1210 Brighton Avenue - Traffic Comments

Hi Nell – I have reviewed the revised site plan and generally find the revisions to be acceptable with the following comments.

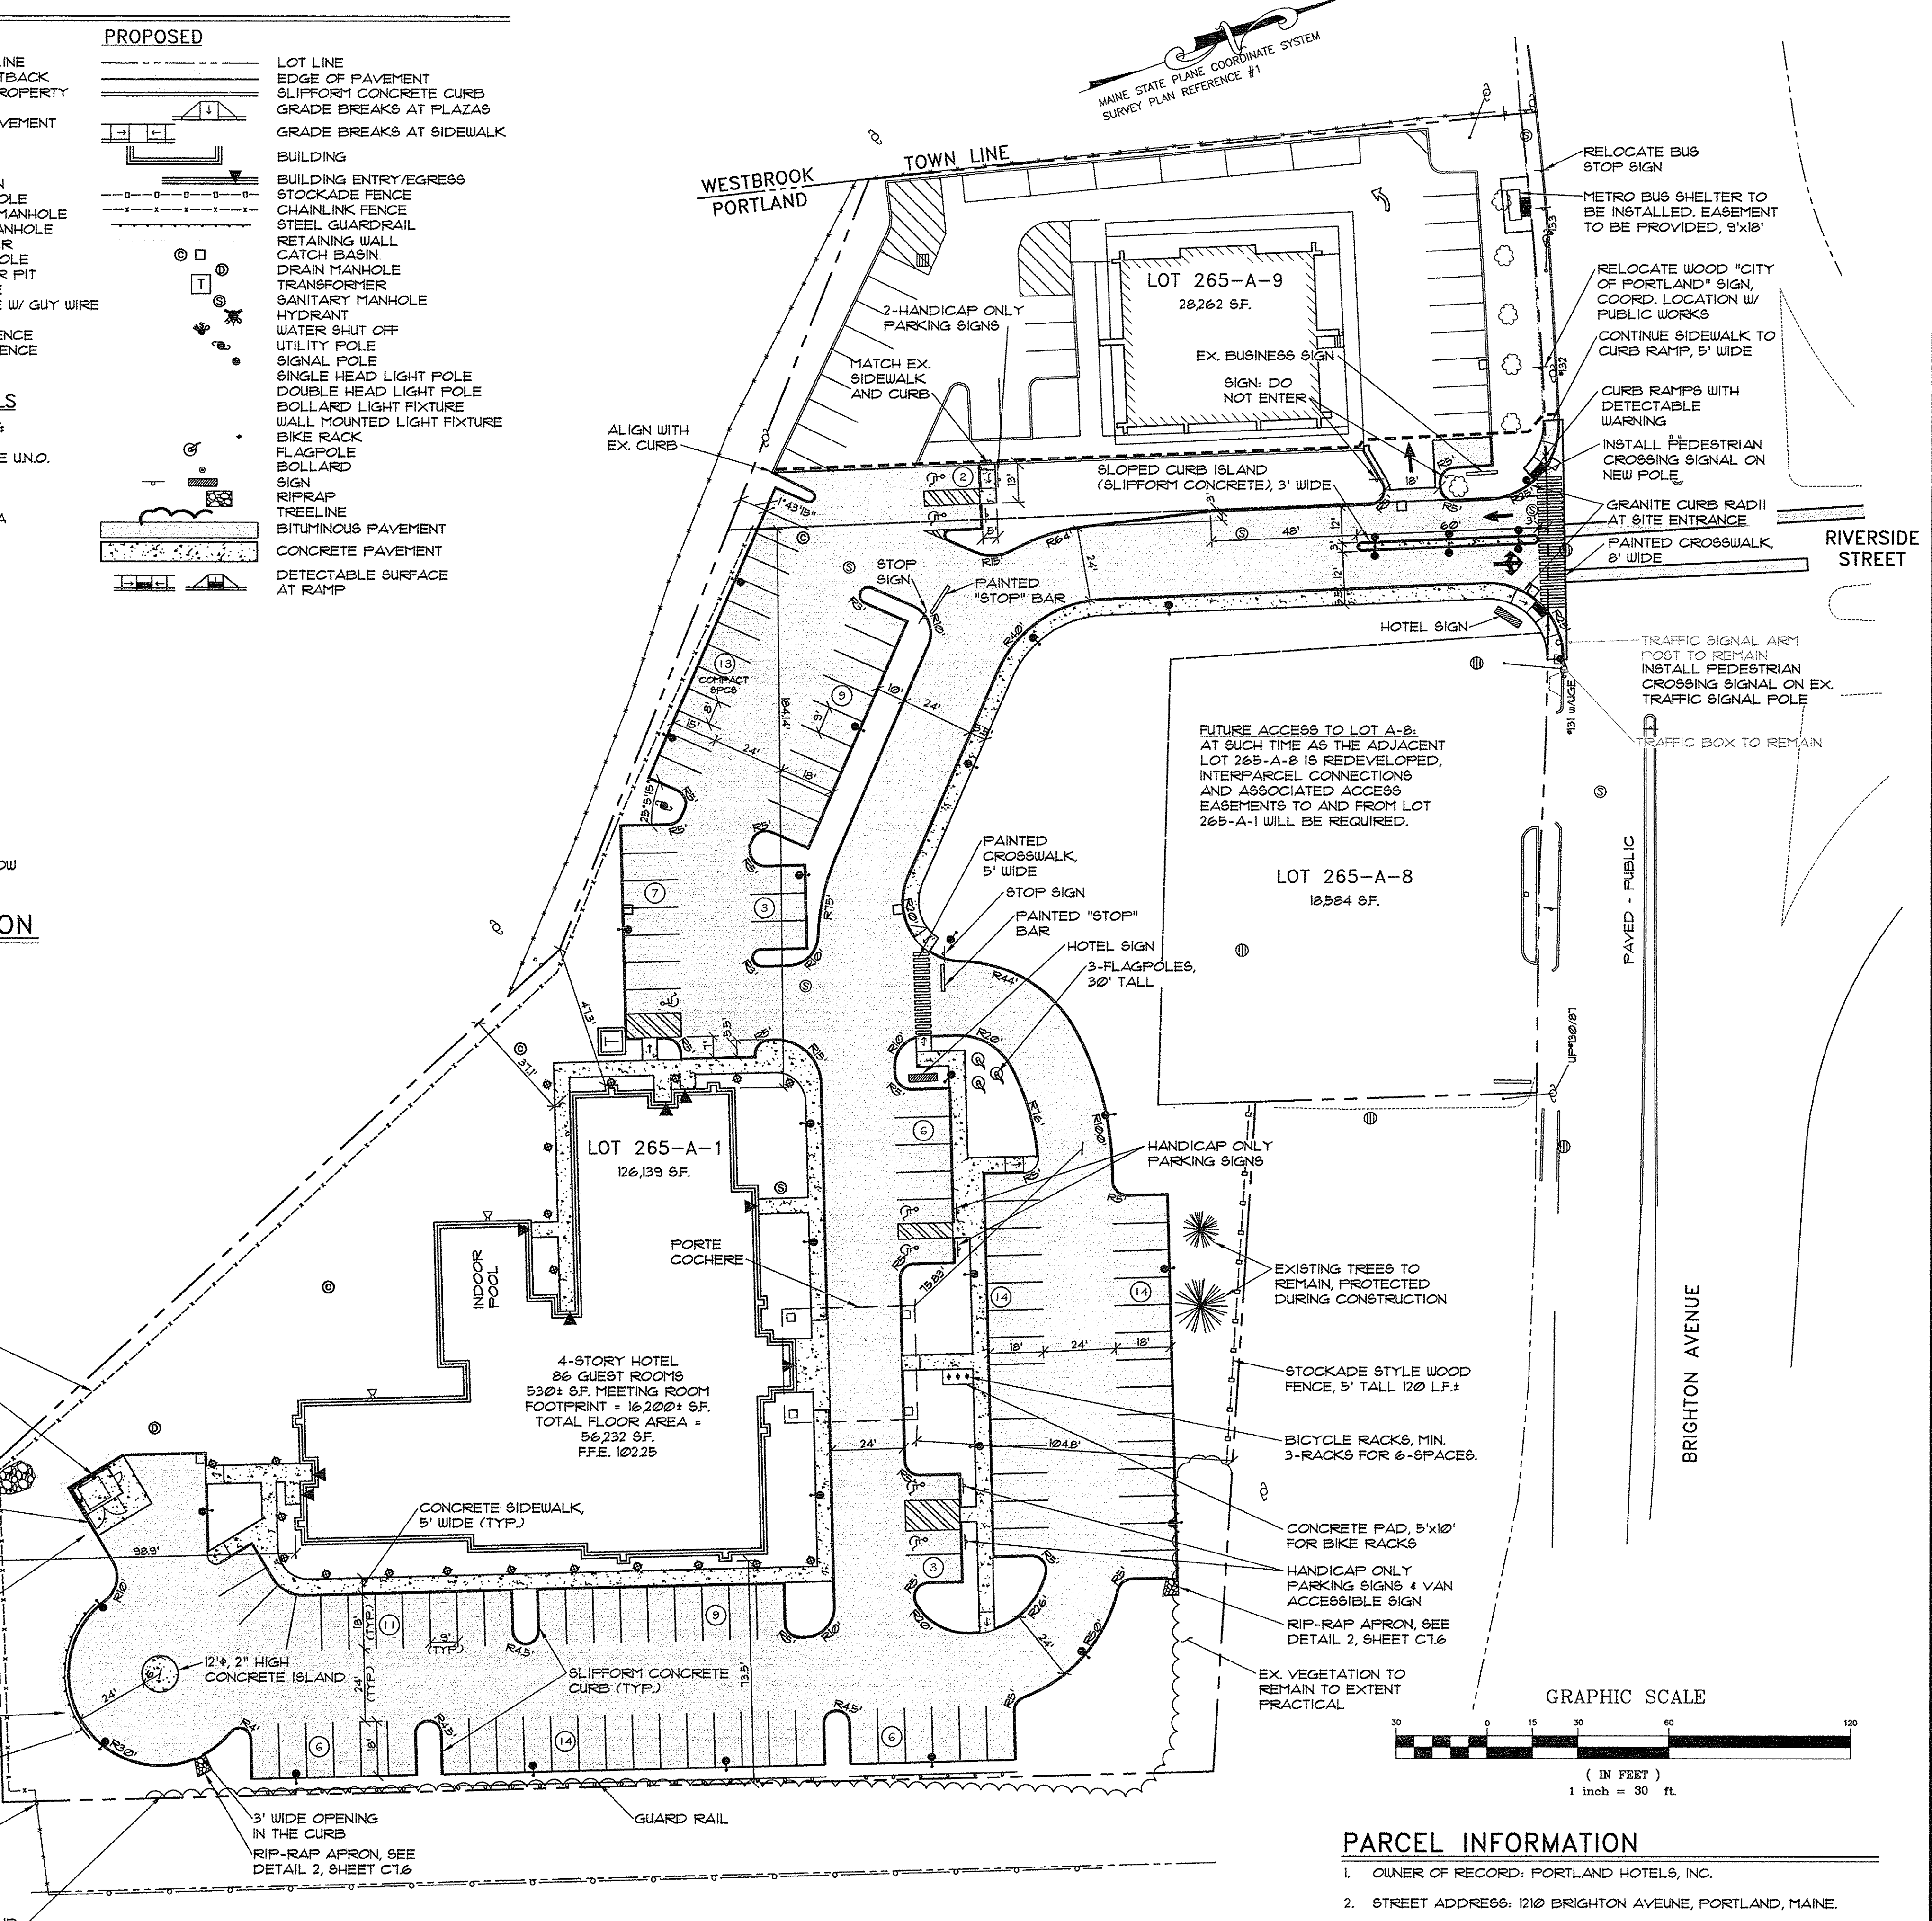
- It is my understanding that you have directed the applicant to delete the formal inter-parcel connections to Lot 265 A-B. I would note that future provision of connections to the subject lot is suggested. For future planning reference, I do have concerns regarding the connection at the main driveway location and the potential to create spill back problems into Brighton Avenue. Implementation of a right-turn entry/exit connection would likely be acceptable. Given that the main driveway connection would have limited access conditions, it would seem appropriate to shift the internal connection closer the Brighton Avenue driveway thus providing a more direct connection.

- The applicant should provide supporting information regarding the design of the internal intersection (where the crosswalk is provided). The information should respond to the following issues:
 - The geometric alignment of the intersection, particularly the use of pavement markings to define the intersection configuration. I would suggest auto-turn information be provided.
 - The location of the crosswalk in relationship to the STOP bar may create unsafe conflicts.
 - Given likely future use by the abutting parcel, this internal intersection has the potential to carry a significant amount of traffic and thus this needs to be a consideration.
 - I would prefer alignment with the opposite parking lot driveway.
 - The design should consider a future pedestrian connection through Lot 265 A-B to Brighton Avenue.
